Application No: CM/48/21/RES
Site Address: Land to the West of Church Lane South of Horsemere Green Lane Climping
Description of works: Approval of reserved matters following the grant of CM/1/17/OUT for the erection of 300 No dwellings & a building within use class E, together with public open space, LAPs, LEAP & ancillary works, including car parking & drainage arrangements, with access off Church Lane & Horsemere Green Lane. This application may affect the setting of listed buildings & is in CIL Zone 4 (HSP2) & is not CIL Liable.

Thank you for your internet representation made on 23rd July 2023 which has been recorded as an objection with the comments as follows:

objection against Substitute Plan/ Detailed planning Plan 7 of 30 L17 rev C

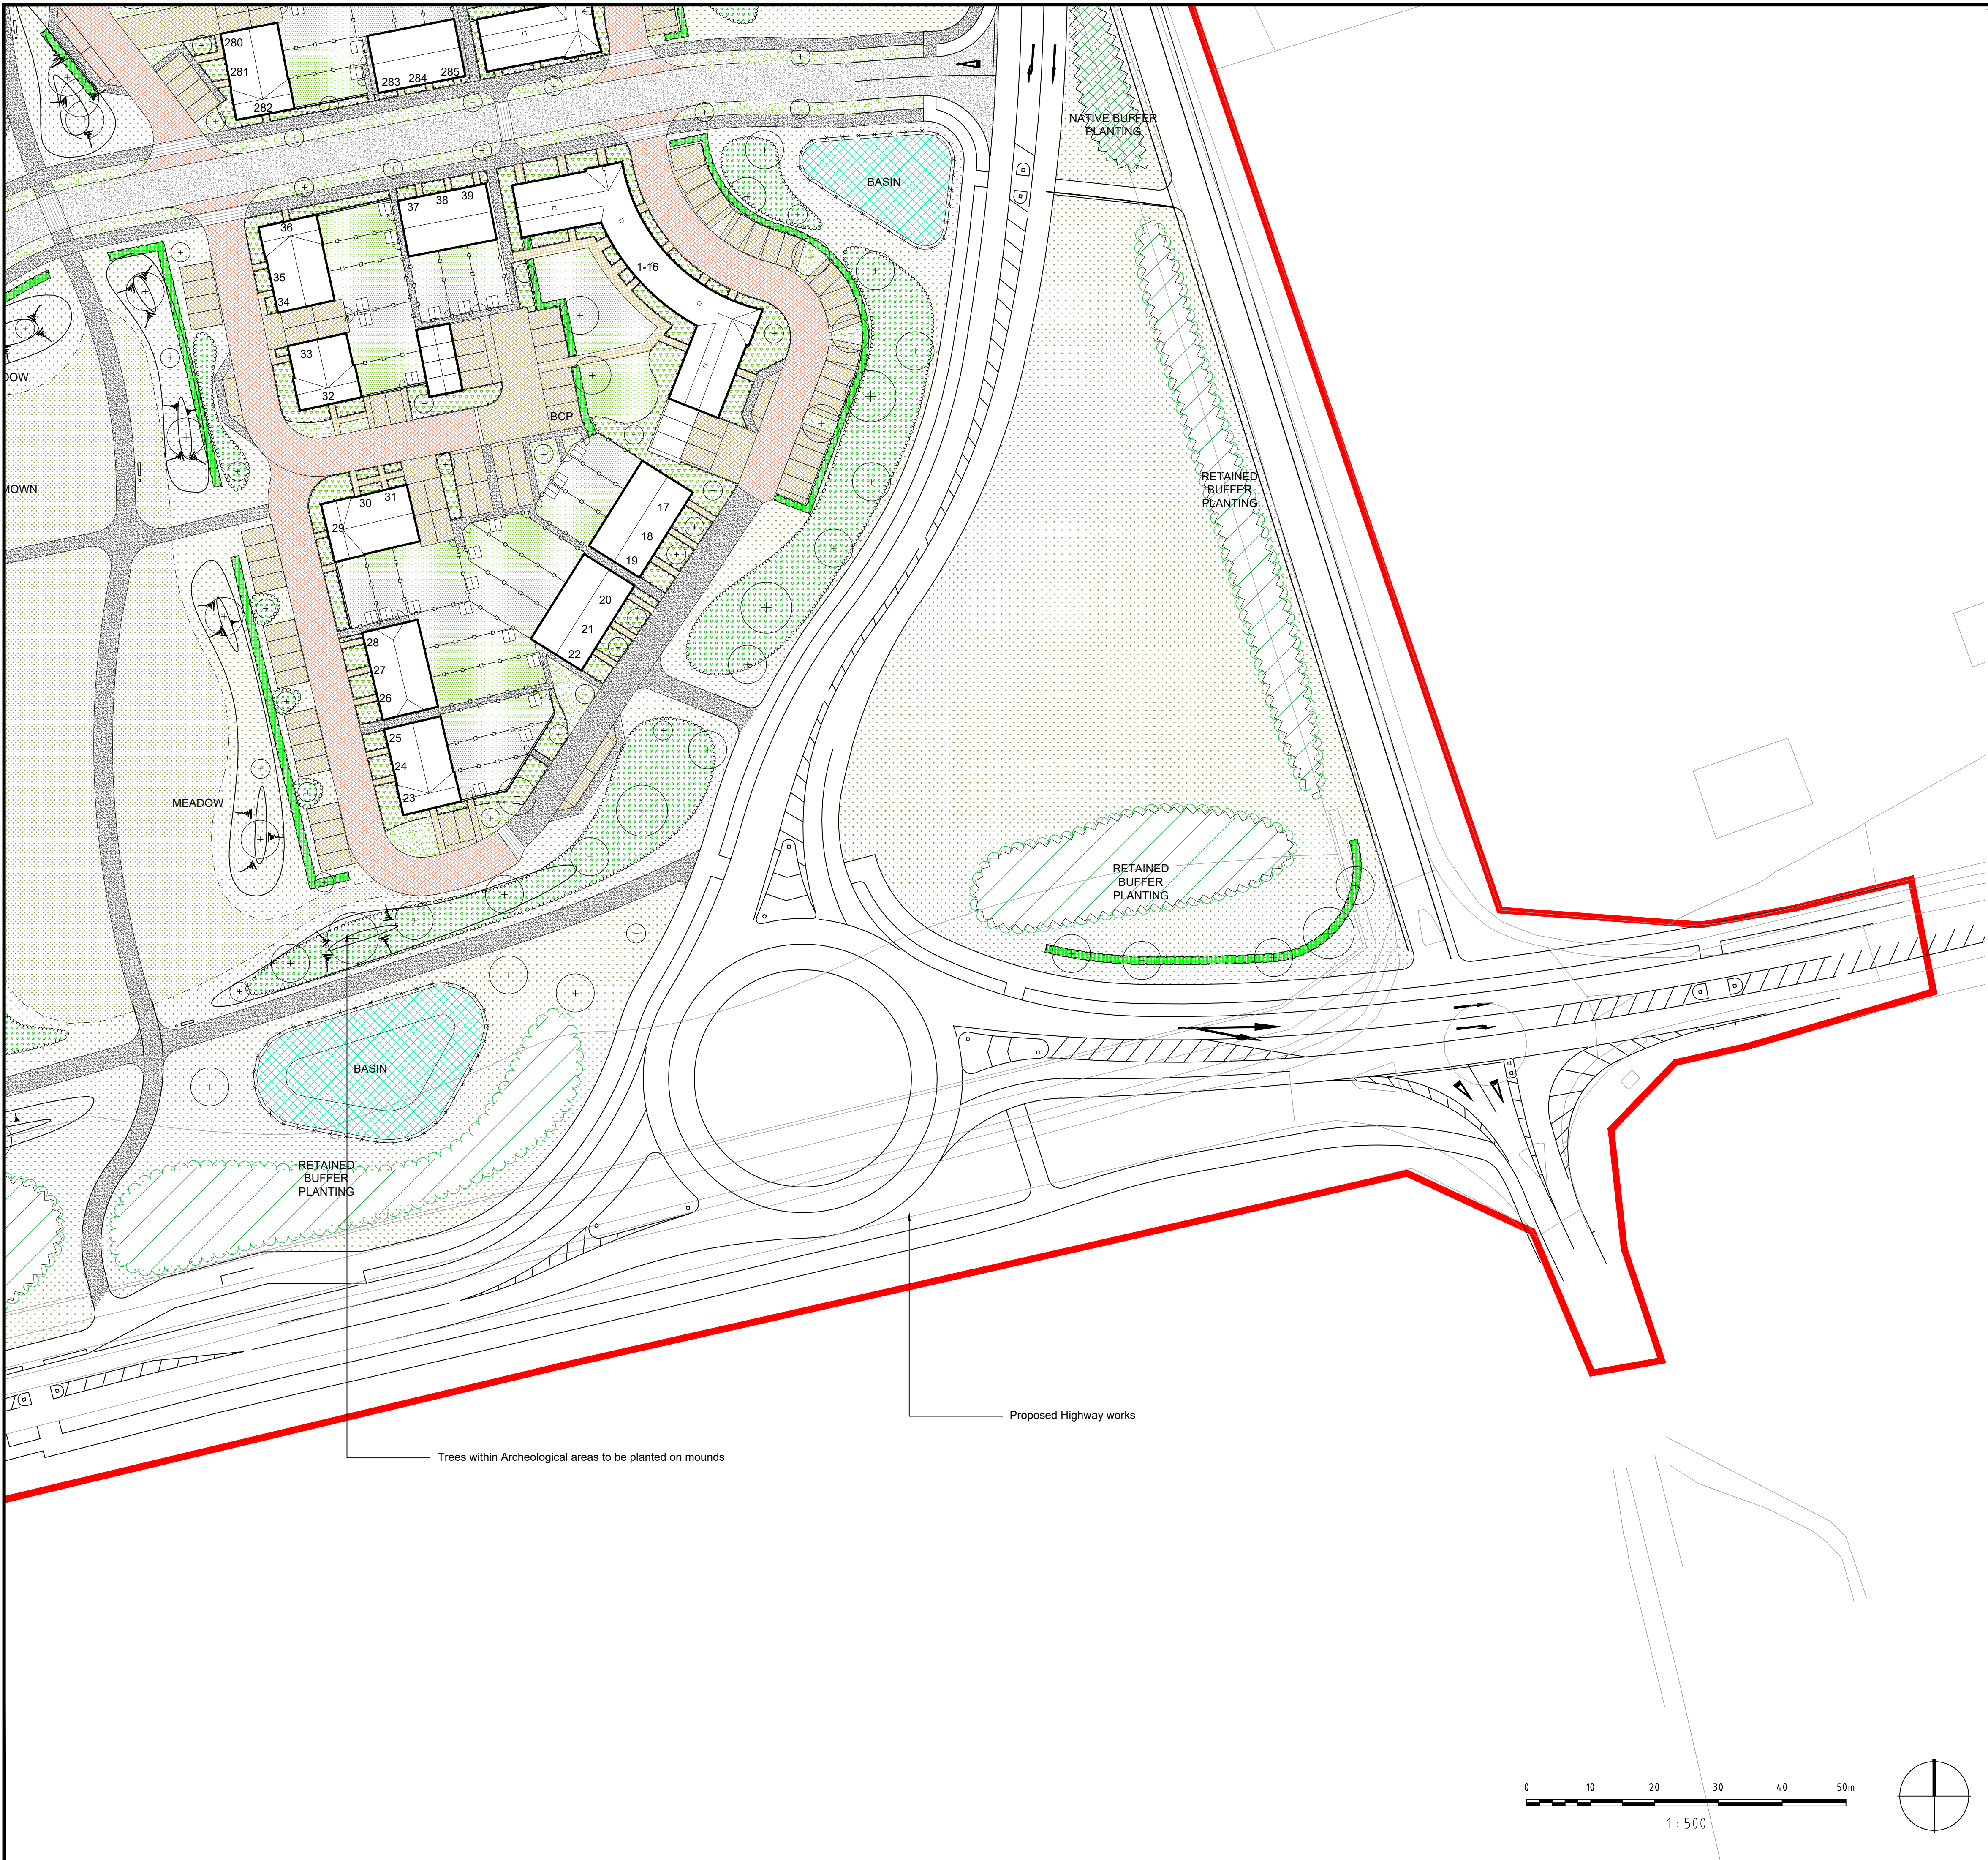
I just noticed that Foreman Homes revised their plans for the development at Climping. We had previously objected against a large tree being planned next to our hedge. Foreman Homes now have named the trees that will be next to our property and this will have an enormous impact on the sun in our back garden.

The following trees are going to be planted along our property;

1. Betula Pubescens 10 x 20 meters high
2. Sorbus Aucuparia 8 x 12 meters high
3. Malus Sylvestris 7 - 9 meters high
4. Salix Caprea 10 meters

Salix Caprea is a Willow family and are known to seek water and their roots will end up under our house and can cause subsidence!

Over the whole length of my garden these trees will in time block a lot of sun out of my garden is for me this is absolutely unacceptable!

In the strongest possible way I am objecting again against the height and kind of trees being planted along side my garden.
